Active
Travel
England

Your Ref: 23/01493/REM
Our Ref: ATE/23/00153/RM
Date: 18 April 2024

Active Travel England Planning Response Detailed Response to an Application for Planning Permission

Site Address: PROPOSED HIMLEY VILLAGE NORTH WEST BICESTER,
MIDDLETON STONEY ROAD, BICESTER, OX26 1RT

TITLE
**S278 OFFSITE HIGHWAY WORKS
PRIMARY ACCESS JUNCTION
GENERAL ARRANGEMENT
SHEET 1**

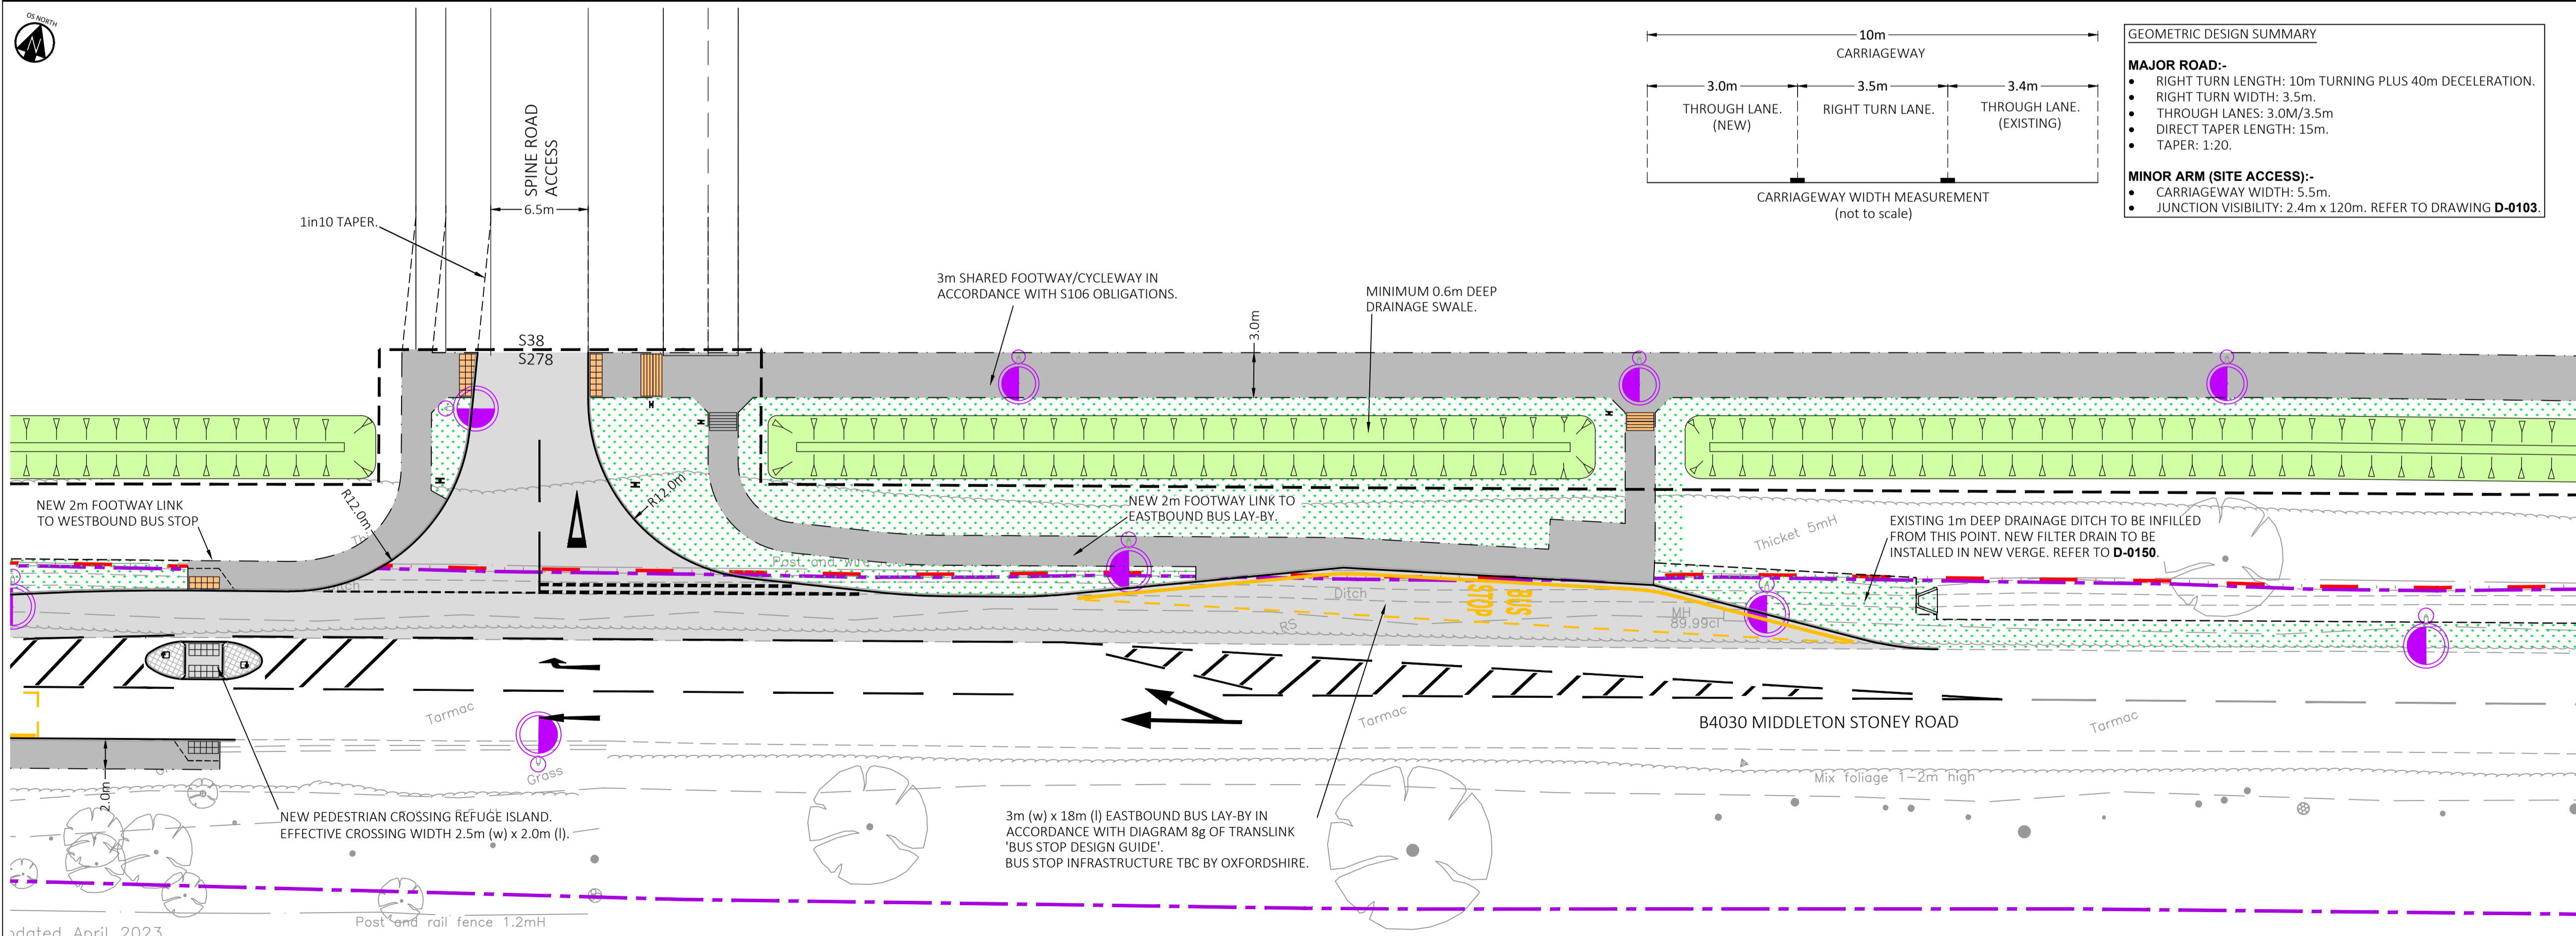
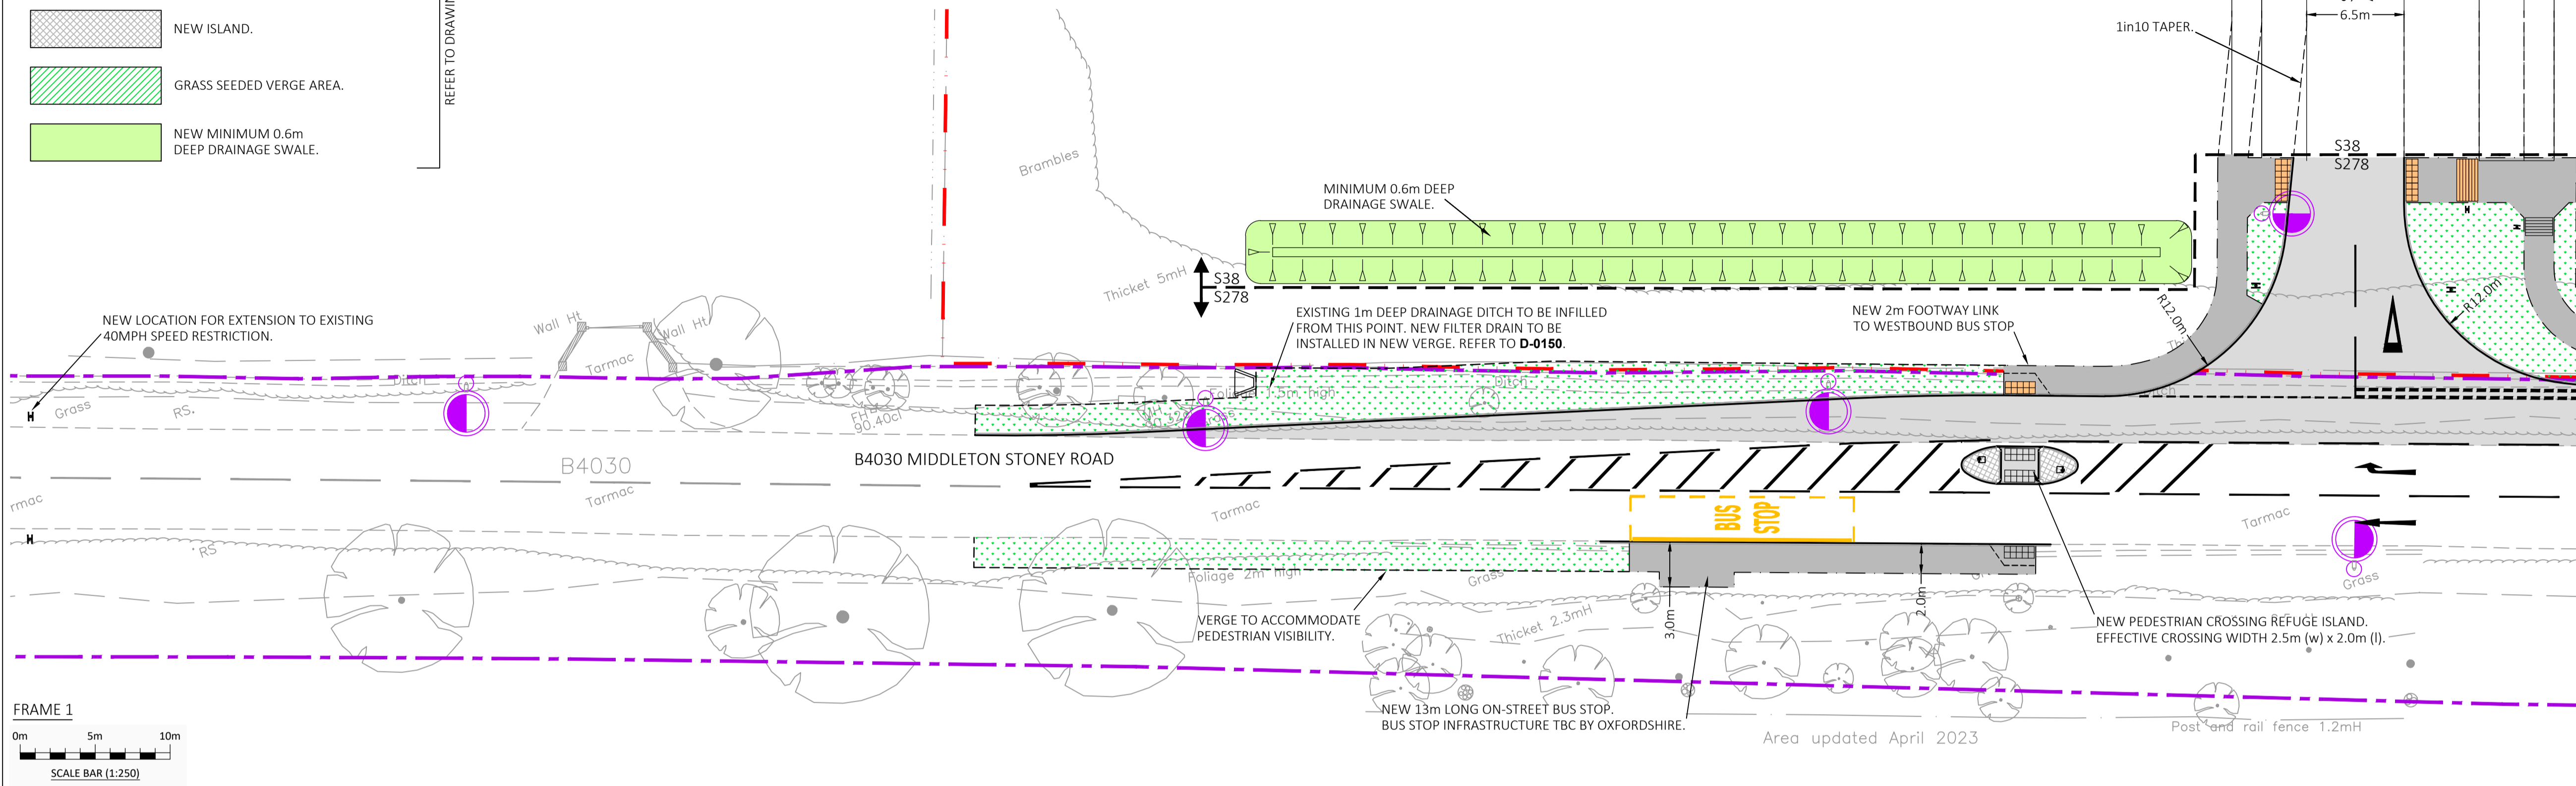
The above improvements are welcome and supported, however it is felt the access to the Primary Spine Road would also benefit from the same priority arrangement proposed at the Secondary Street access. This would assist those joining infrastructure within the proposal site as well as future proofing connections to the west.

Concern was raised regarding the uncontrolled crossing towards the bus stop on the southern side of B4030 Middleton Stoney Road. It was recommended that a signalised crossing be provided in view of the nature of the road and the likely increase in movements generated by surrounding growth.

TITLE
**S278 OFFSITE HIGHWAY WORKS
SECONDARY ACCESS JUNCTION
GENERAL ARRANGEMENT
SHEET 2**

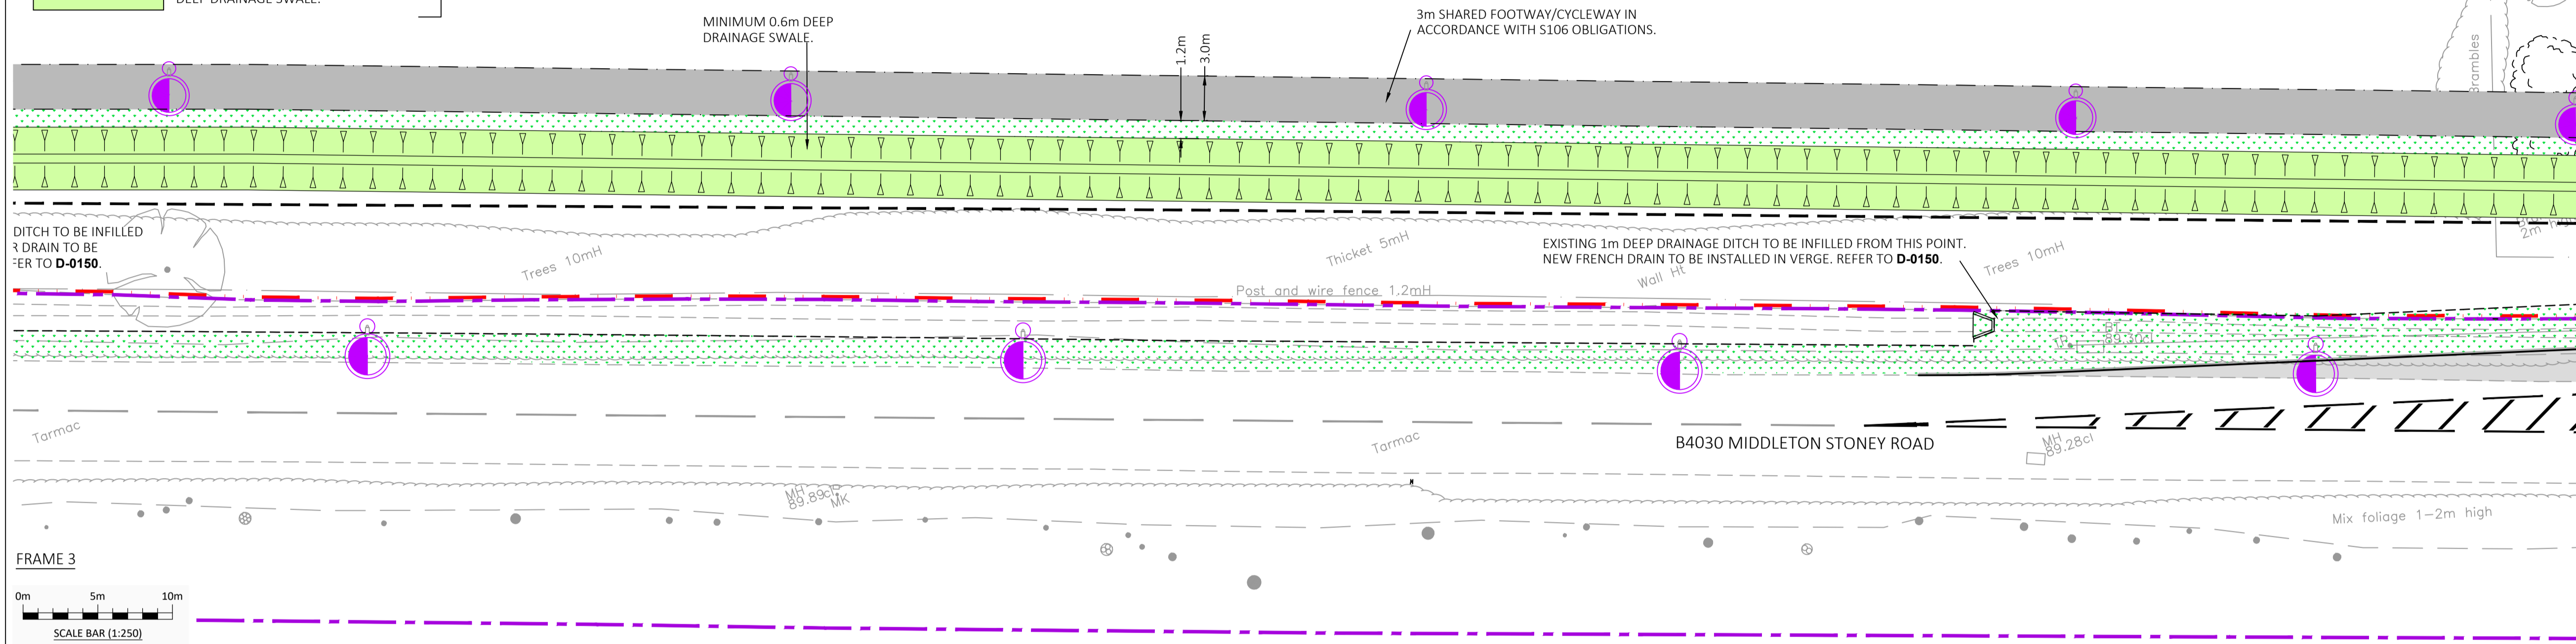
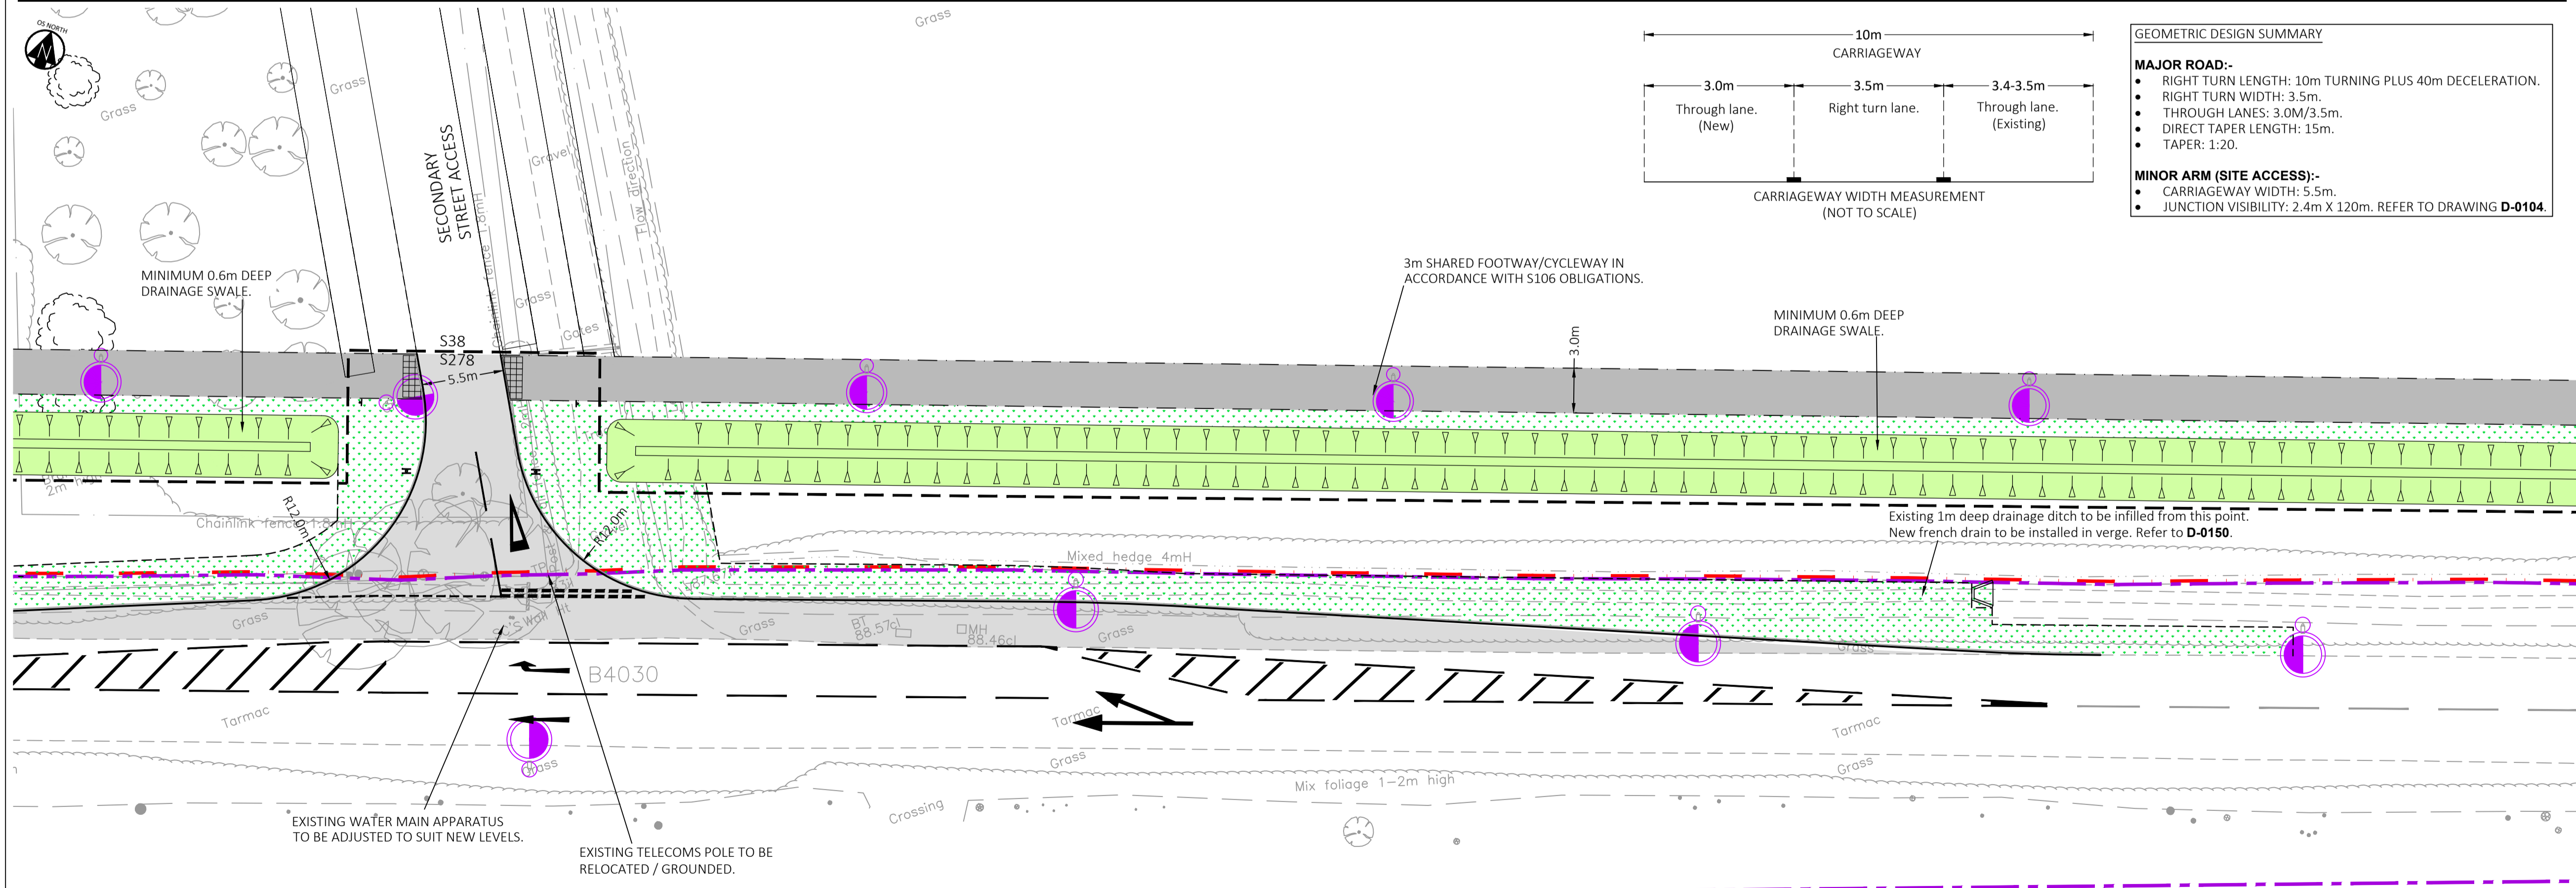
- A 'lazy S' bend has been introduced to ensure a smooth transition between the on site 4 metre wide footway / cycleway and the off site 3 metre wide footway / cycleway.
- A continuous footway/cycleway has been provided at the entrance to the Secondary Street from B4030 Middleton Stoney Road with vehicles required to give way.
